Your ref: SSD-10396  
File no: MC-19-00007

**SSD-10396 - Request for advice – Kings Park Metal Recovery and Recycling Facility Expansion at 23 - 45 Tattersall Road, Kings Park**

# **Blacktown Council's submission to SSD 10396 – Kings Park Metal Recovery and Recycling Facility Expansion at 23 - 45 Tattersall Road, Kings Park**

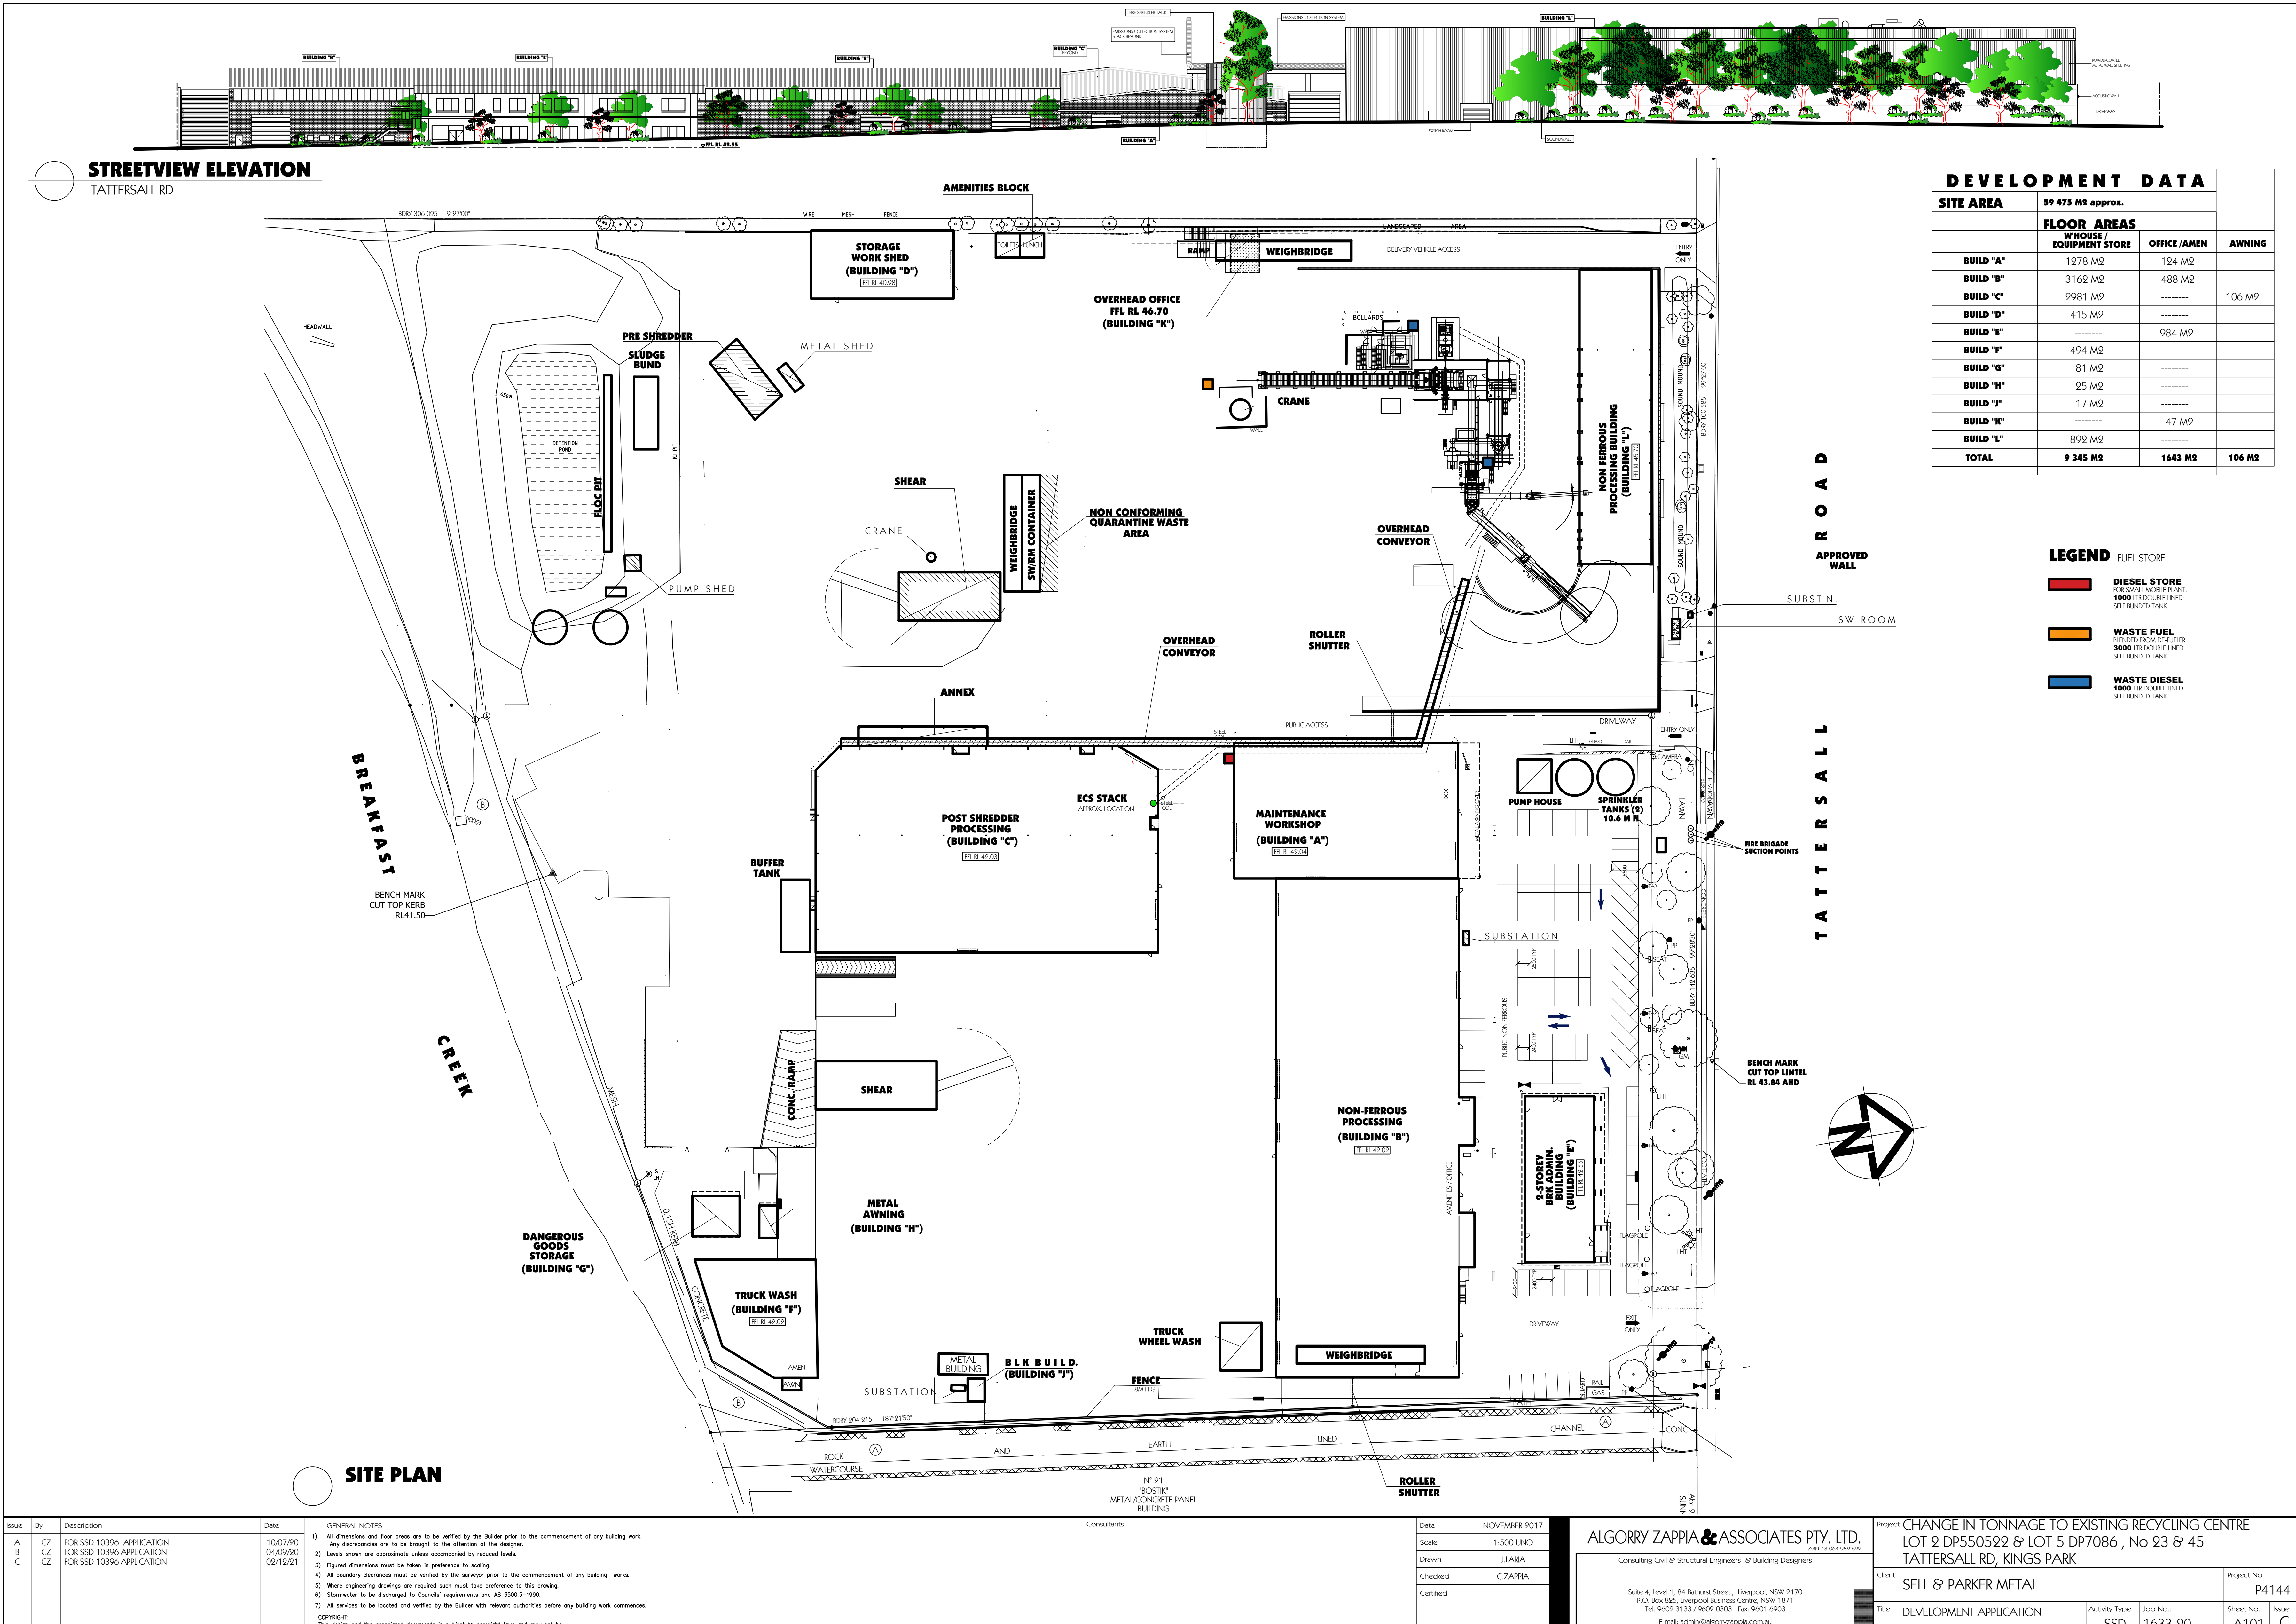
- a. Both the:
  - submitted document - which aims to address neighbouring concerns
  - Addendum Noise Impact Assessment prepared by Renzo Tonin & Associates and dated 20 December 2021,

outline the need for and the applicant's intention to increase the acoustic barrier from 8 to 16m along the eastern boundary. However, the specific details of the proposed acoustic barrier have not been clearly shown on the site and elevation plans.
- b. Additional information is required to illustrate clearly the proposed location, length, construction materials and potential impacts of the proposed acoustic barrier. The potential impacts for the site and surrounding properties, have not been adequately considered in the applicant's response, in particular:
  - neighbourhood amenity, the bulk, scale and shadow impacts of the barrier
  - the potential streetscape impacts specifically if the proposed 16m acoustic barrier is orientated towards the nearby residential area. Insufficient street scene views and treatment details have been provided.
